March 5, 2020

**RE: Ryan's Sewing & Vacuum
5011 San Mateo Blvd NE
Grading and Drainage Plan
Engineer's Stamp Date: No Date
Hydrology File: F17D103**

Based upon the information provided in your submittal received 02/19/2020, the Grading & Drainage Plan **is not** approved for Building. The following comments need to be addressed for approval of the above referenced project:

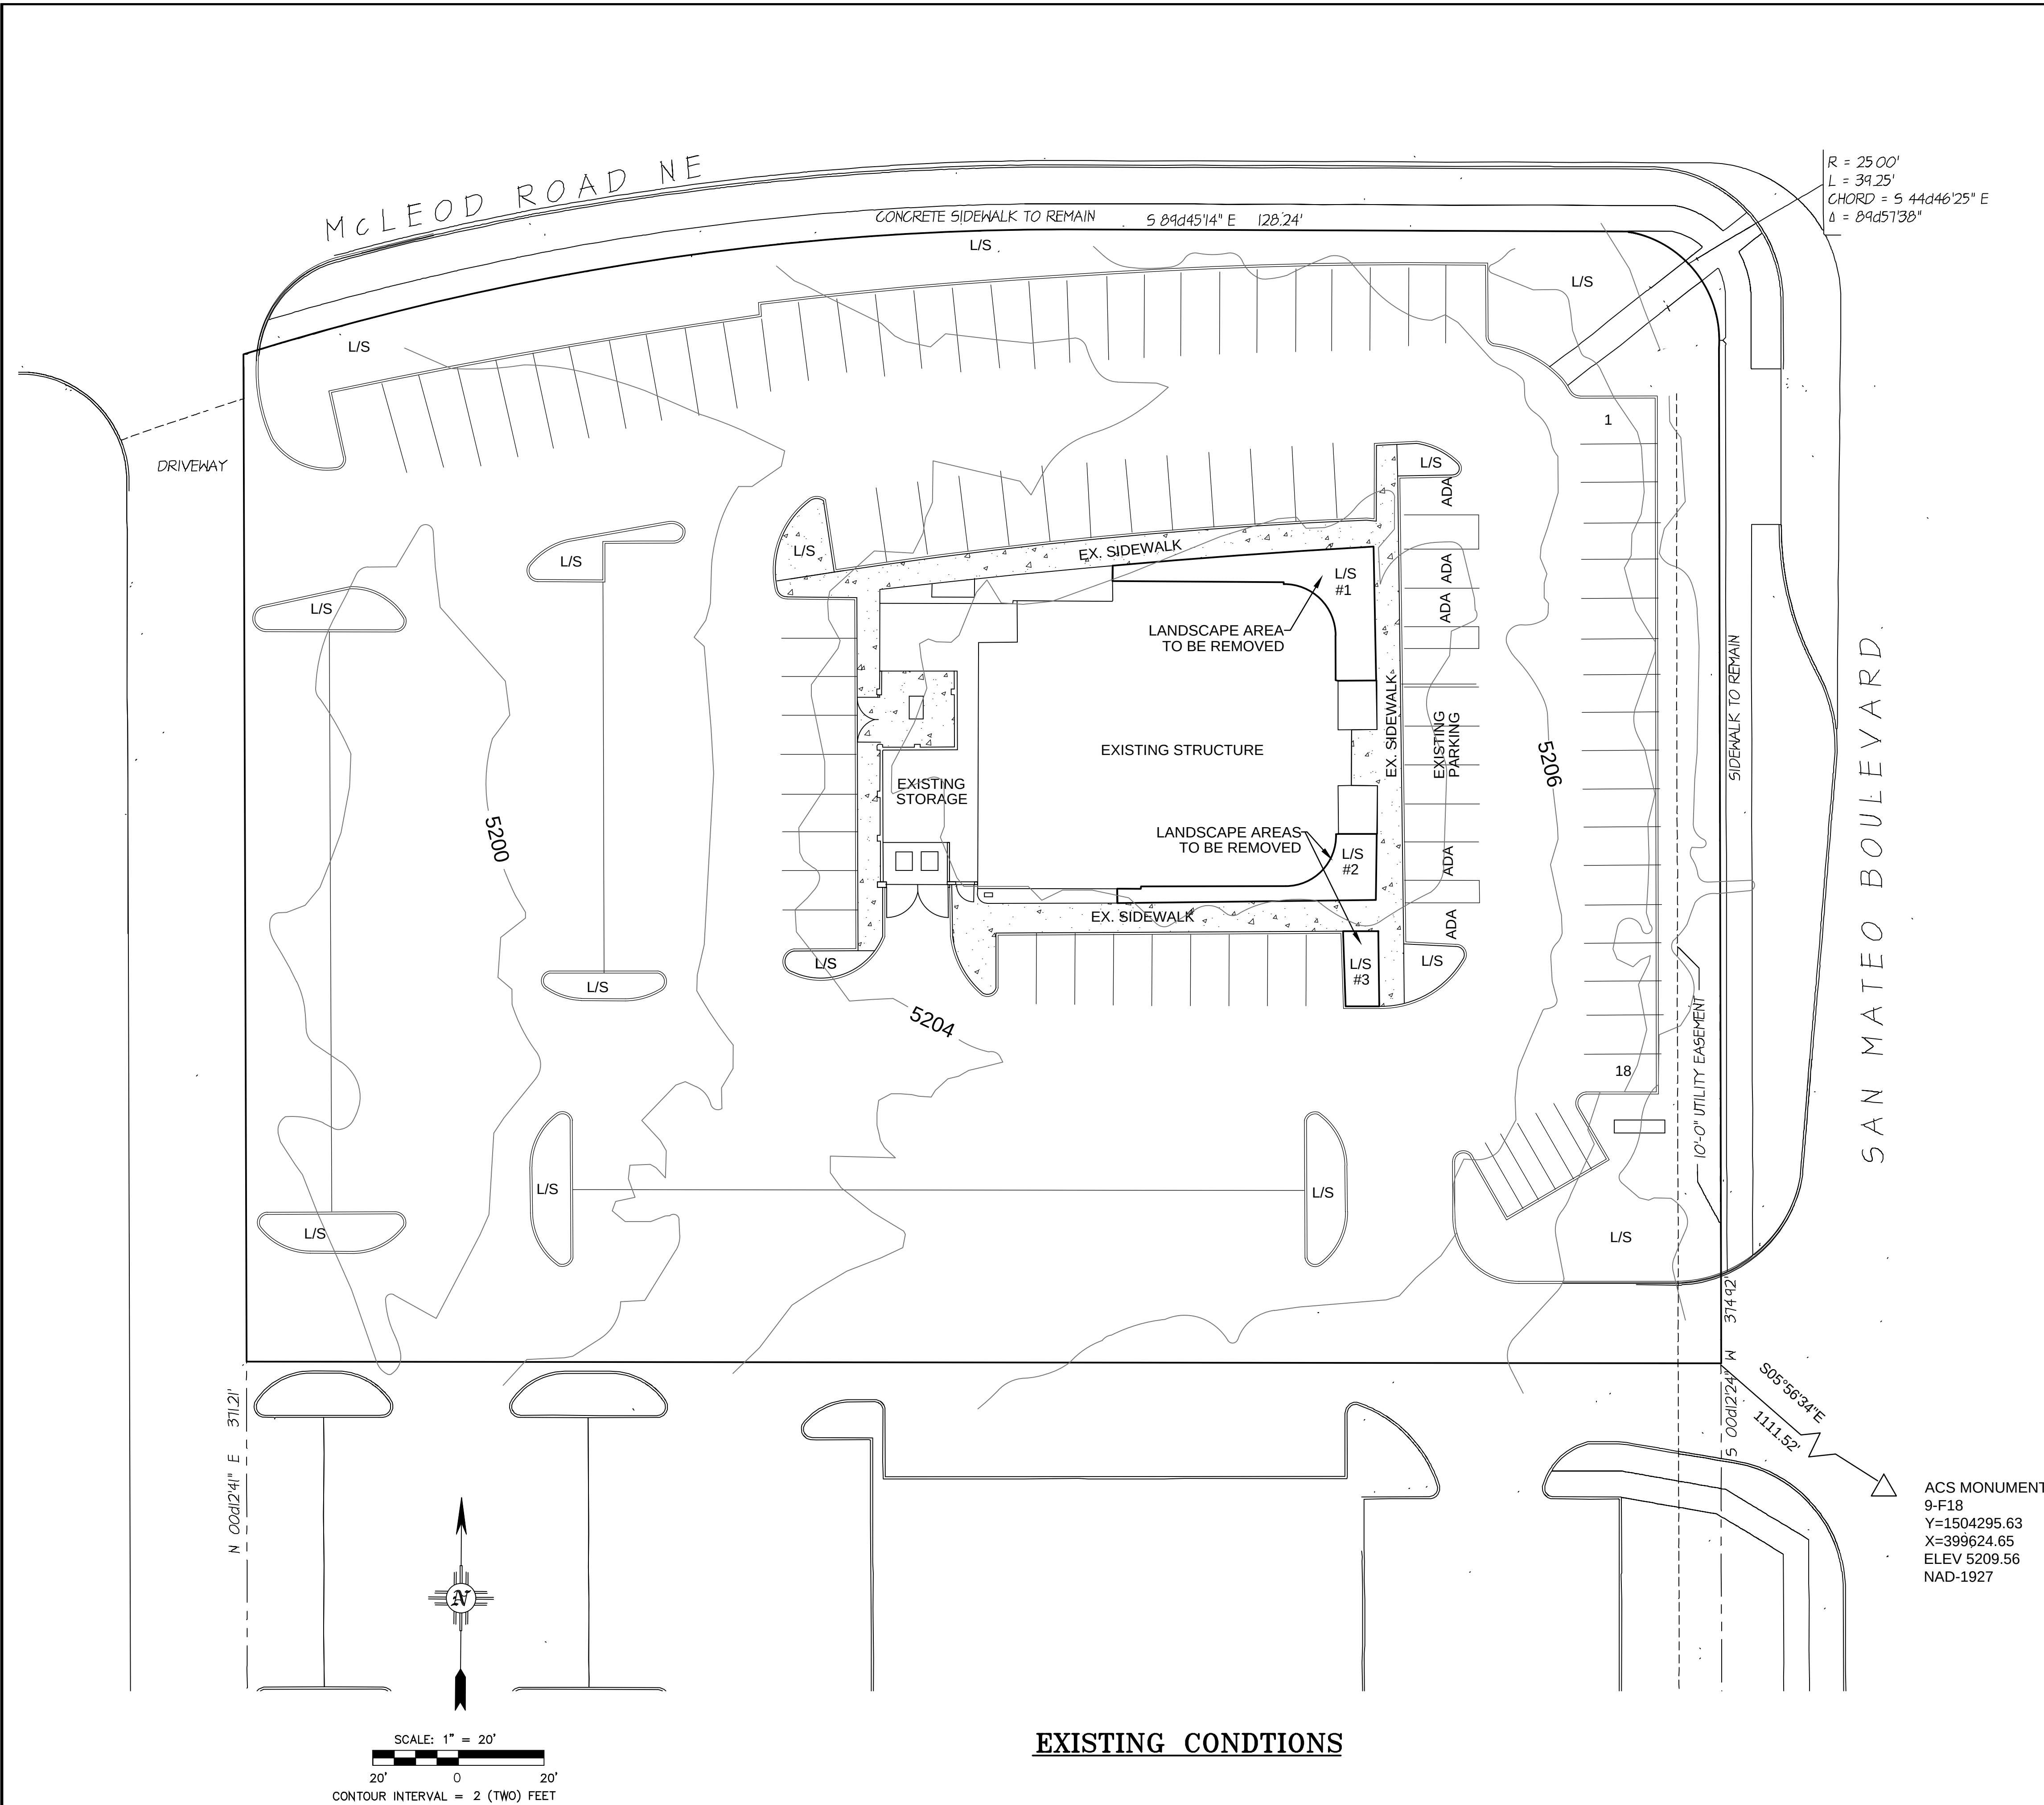
1. Please provide all missing information from the Grading Plan Checklist. **(a, c, d, e, & f)**
Per the DPM Chapter 22 Section 7 - Grading Plan Checklist, the following must be on the Grading Plan. Please add an Engineer's Stamp Date.

- a. Please provide an engineer's stamp with a signature and date.
 - b. Please use 1" = 20' for the scale.
 - c. Please provide a Vicinity Map.
 - d. Please provide the Benchmark information (location, description and elevation) for the survey contour information provided.

- e. Please provide the FIRM Map and flood plain note with effective date.
 - f. Please provide a legal Description of the property.
2. Please use the procedure for 40 acre and smaller basins as outlined in Chapter 22, Part A of the Development Process Manual (DPM). Please provide both the existing conditions and proposed conditions for the 100 year-6 hour storm event. This site is in Precipitation Zone 4. Then you can accurately state if there is an increase, decrease, or the same runoff as the existing conditions.

3. The storm water quality (SWQ) volume for this site is required in order to manage the storm water runoff. Since this is a redevelopment site, the storm water quality volume is calculated based on the 0.48 inch storm. To calculate the required storm water quality volume to be captured, multiply the impervious area by 0.28 inches for the 80th percentile storm. This required storm water quality volume can be captured within the

depressed areas of the landscaping. Please also state the total provided storm water quality volume for the site.

4. Please provide the weir calculations for the curb cuts per the DPM. A coefficient of 2.7 is typically used for the equation (6.60) $Q = CLH^{2/3}$.
5. As a reminder, if the project total area of disturbance (including the staging area and any work within the adjacent Right-of-Way) is 1 acre or more, then an Erosion and Sediment Control (ESC) Plan and Owner's certified Notice of Intent (NOI) is required to be submitted to the Stormwater Quality Engineer (Doug Hughes, PE, jhughes@cabq.gov, 924-3420) 14 days prior to any earth disturbance.
6. Also as a reminder, please provide a Drainage Covenant for the proposed detention ponds per Chapter 17 of the DPM prior to Permanent Release of Occupancy. Please submit this on the 4th floor of Plaza de Sol. A \$25 fee will be required.
7. Standard review fee of \$150 will be required at the time of resubmittal.
